CITY OF ALBUQUERQUE

February 19, 2014

RE: **McDonalds – McMahon Marketplace**
– 5700 McMahon Blvd. NW
Grading and Drainage Plan for Building Permit c mwt #1
File: **A11-D011B**
PE Stamp: 12/20/13

Based upon the information provided in your submittal received 1/8/2014, the subject Grading and Drainage plan cannot be approved for Building Permit. The following comments need to be addressed prior to approval:

ISAACSON & ARFMAN, P.A.
 Consulting Engineering Associates
 128 Monroe Street N.E.
 Albuquerque, New Mexico 87108
 Ph. 505-268-8828 www.isaacson.com
 1998 CG-101.dwg Dec 02, 2013

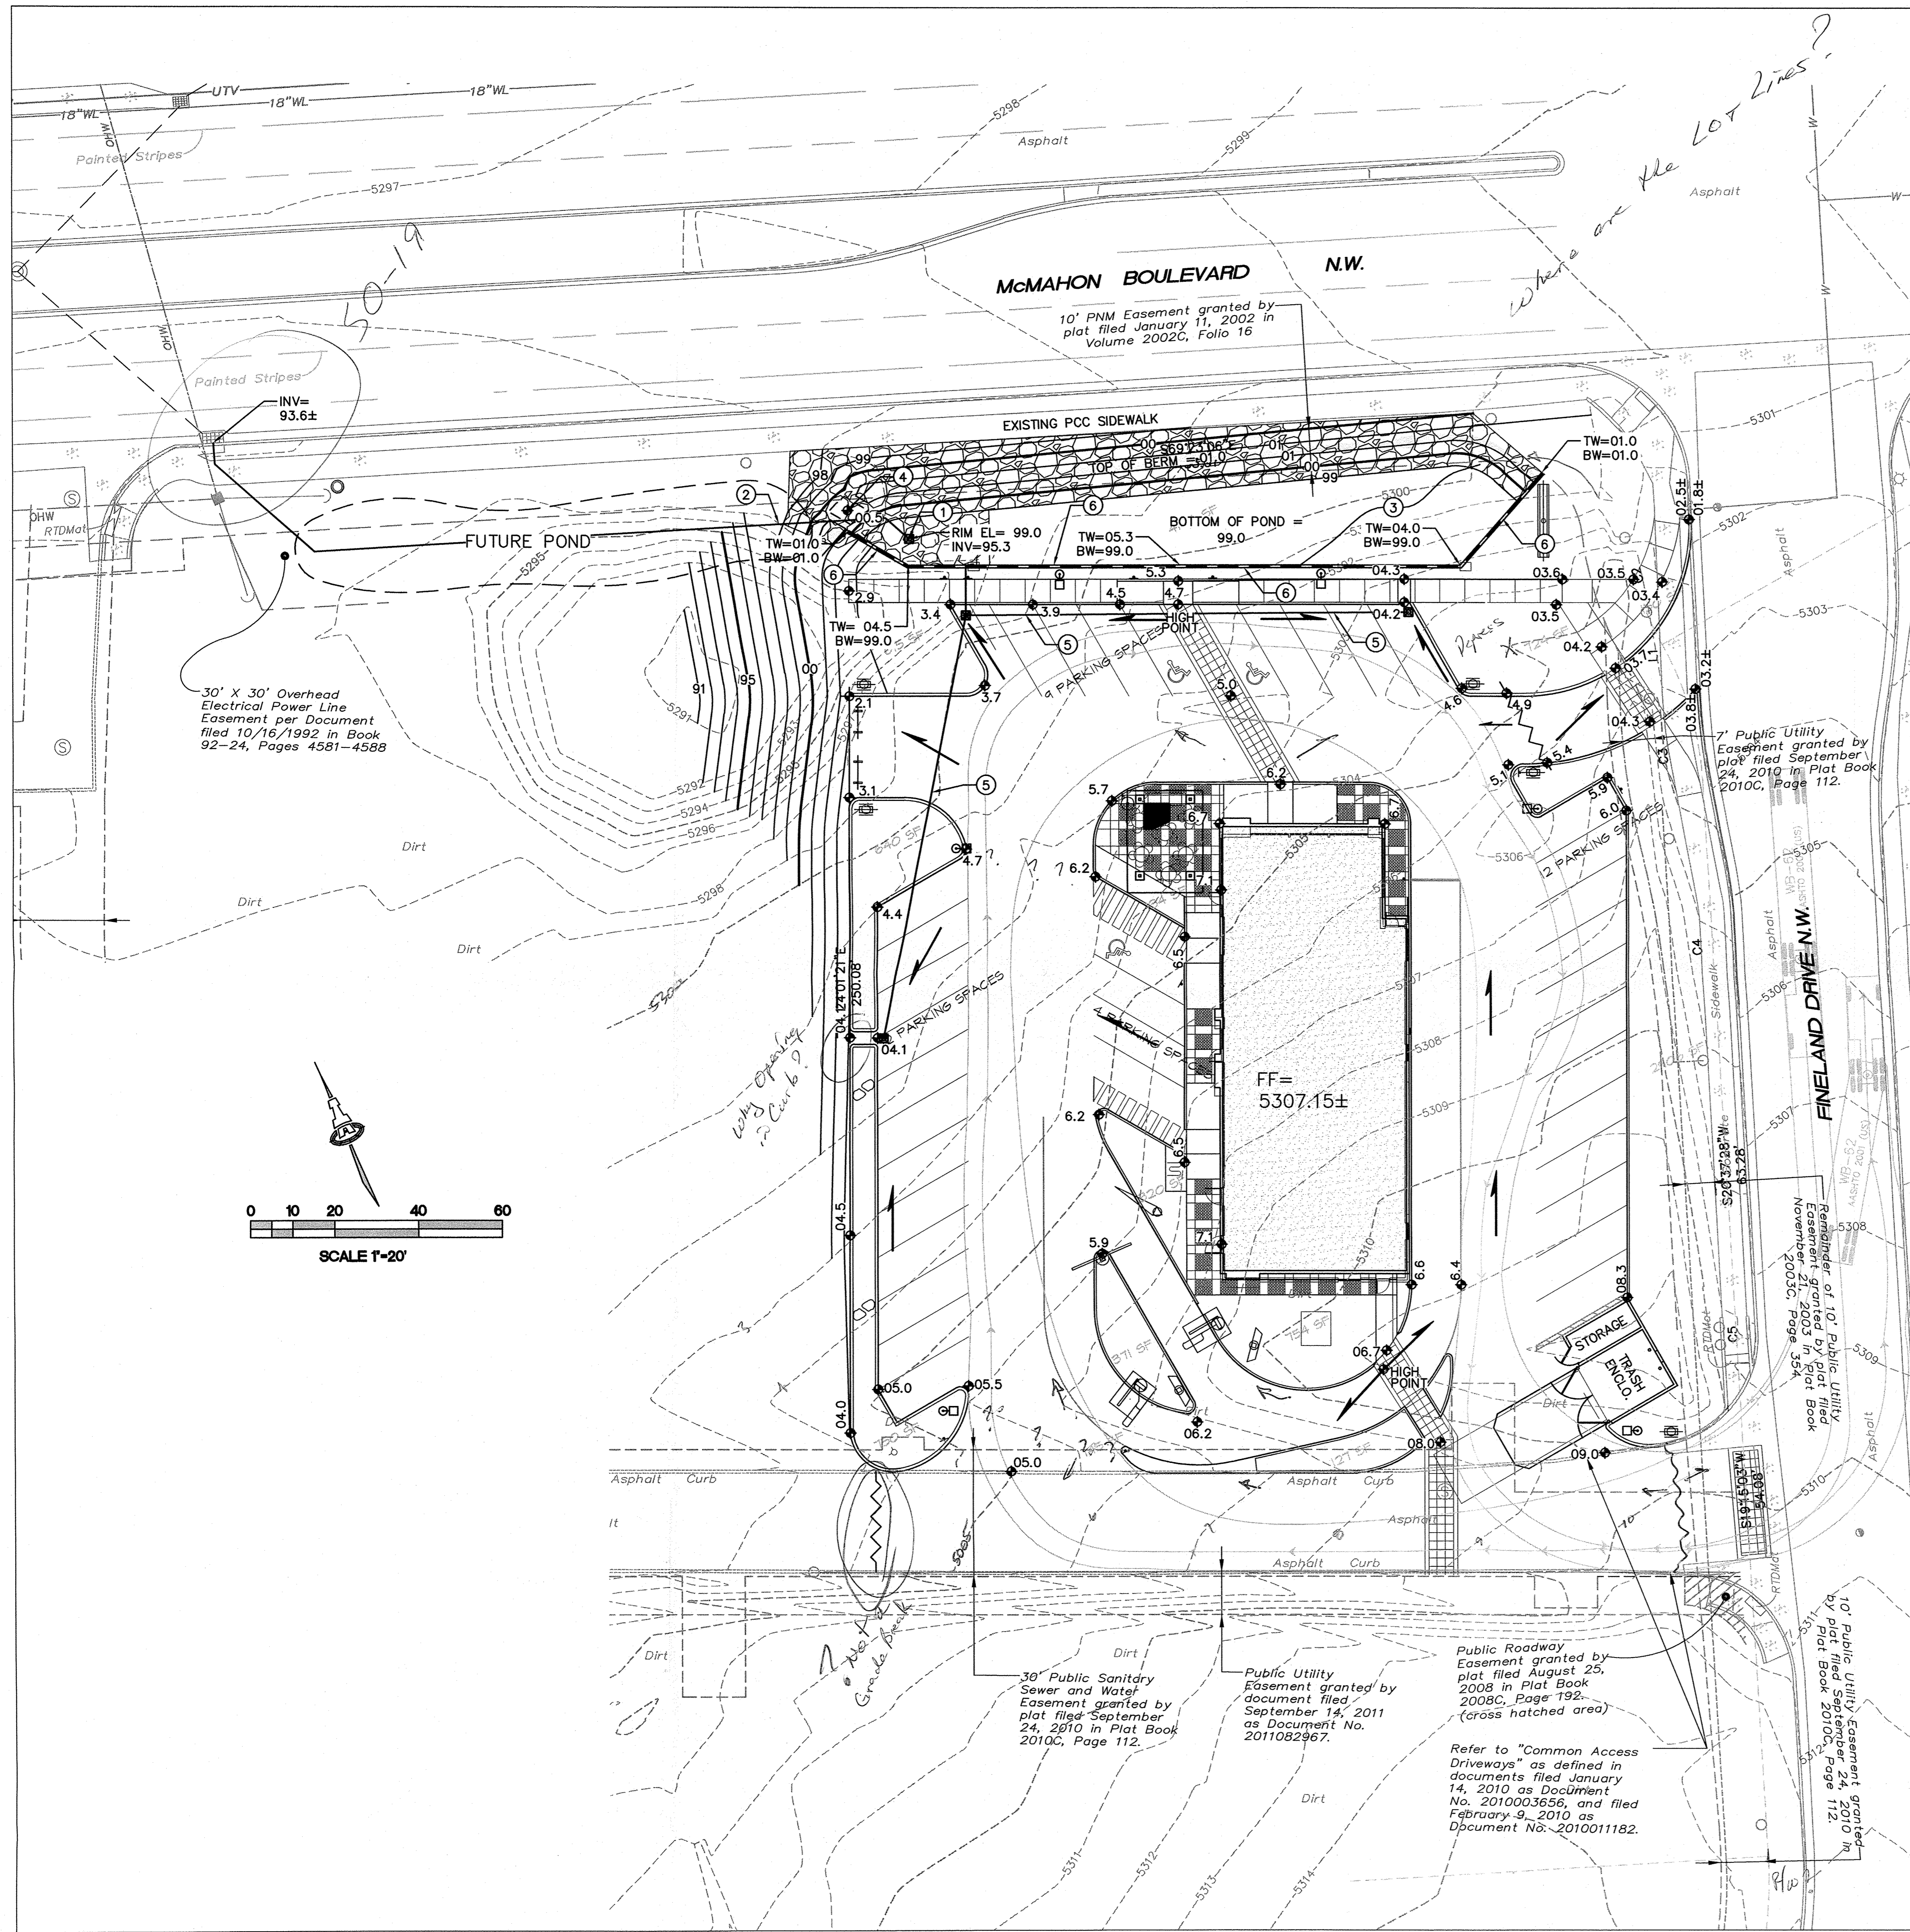
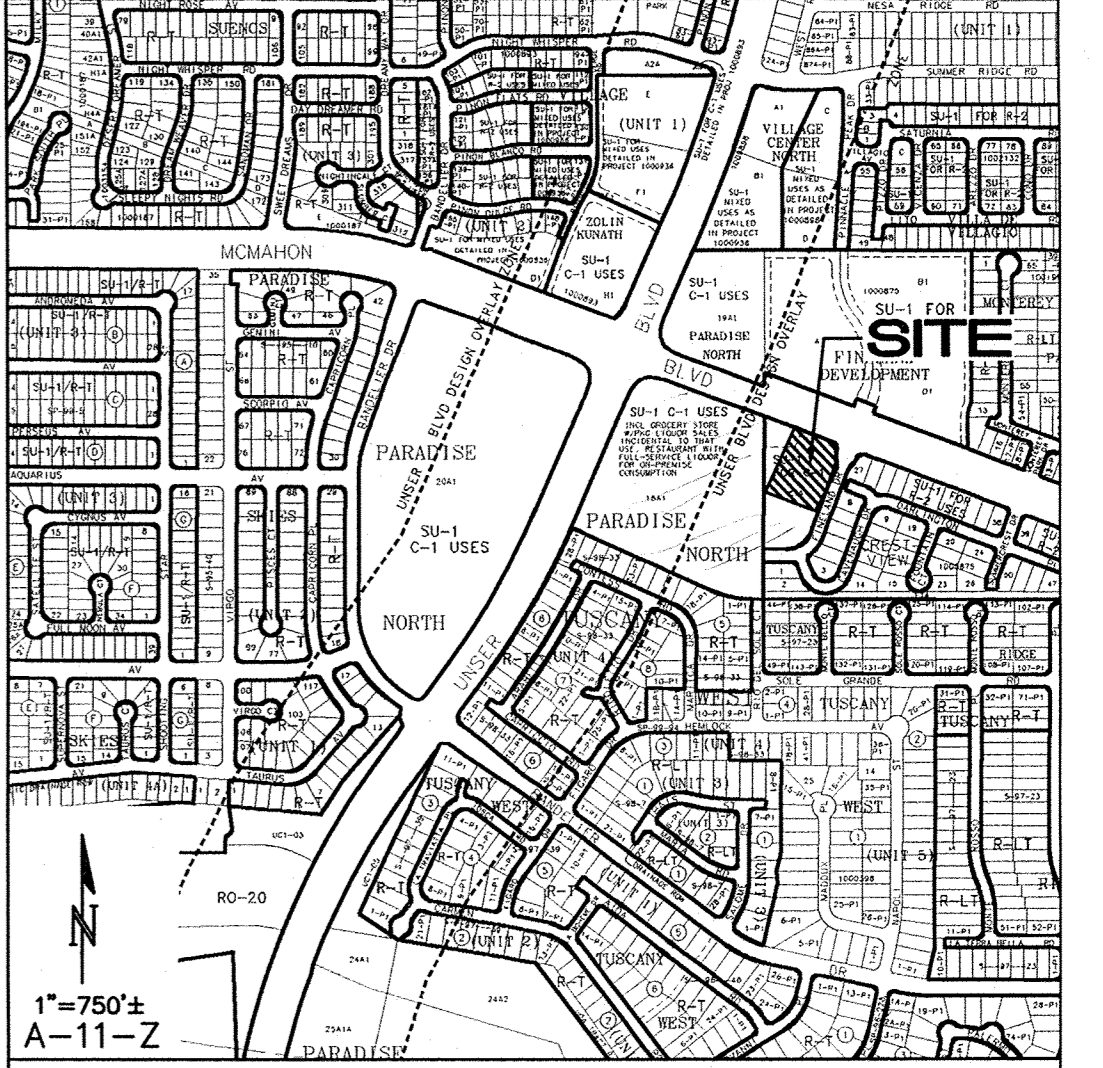
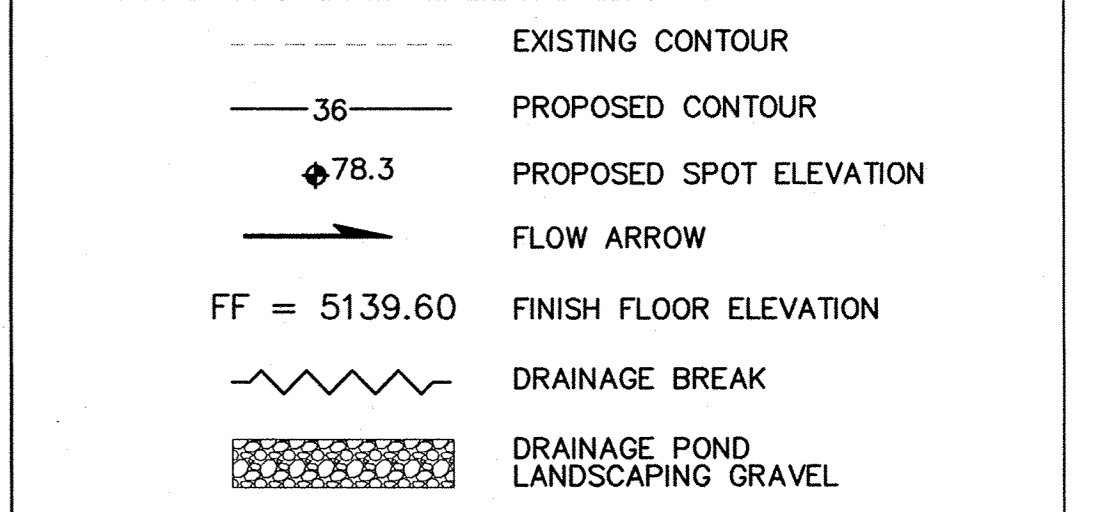
1. The approved Drainage Management Plan for the McMahon Marketplace (Hydro-file A11D011, prepared by Bohannon Huston, Inc., PE seal:5/7/2010) established a detained, maximum site discharge rate of 41.55 cfs for the Marketplace. This portion of Basin D, as shown on that Plan, is thus limited to 3.42 cfs/ac.

2. This plan must include the following details for the detention pond and outfall pipe:
 - a. Pond inflow, outflow, and volume calculations; AND list Pond Specifics, which will be part of the as-built certification (Bottom Elevation, Top elev., Spillway elev., volume required, volume provided, freeboard, etc.).

- b. Provide outflow control details (weir or orifice plate) to limit the pond discharge rate, and minimize clogging and maintenance;
 - c. Provide Top of Wall and Bottom of Wall grades and locations for the retaining wall;

- d. Outfall pipe details, including sizing the connection to the City inlet to accommodate future discharge from the remainder of Basin D, without an additional connection to the inlet structure;

- e. Provide Special Order 19 (SO-19) Notes and details for the Private Storm Drain connection to the Public Storm Drain Inlet on McMahon. Sample Notes and COA Standard Details are attached. Include a signature block for Inspector Approval.

3. Depress landscape areas, where possible, for water harvesting (e.g.- between the sidewalk and parking lot in Basin A-2, the 70% pervious area of A-8, and the buffer strip and NE island in A-9). Provide enough spot elevations around and in the depression to guide construction.

4. Provide erosion protection where flow discharges from Basin A-9 to the dirt slope (adjacent lot) at the NE drive lane. As discussed by phone, it would be preferable to put a water block across that driveway, and divert flows to the detention pond.

5. Some basins on Sheet C8.1 discharge to locations other than that proposed by the approved DMP. They do not appear to be large enough to impact offsite facilities, however the developed flow rates must be deducted from that allowed from the detention pond, and may result in a larger detention pond volume (e.g.- Basin A-2 drains to Finland, and much of A-9 flows out the driveway to the adjacent tract).

6. Per the DPM Chapter 22 Section 9, the Dumpster Enclosure Pad must drain through a grease separator to the sanitary sewer. Provide spot elevations, plus build notes and details, or refer to details on the Utility Plan, if applicable.
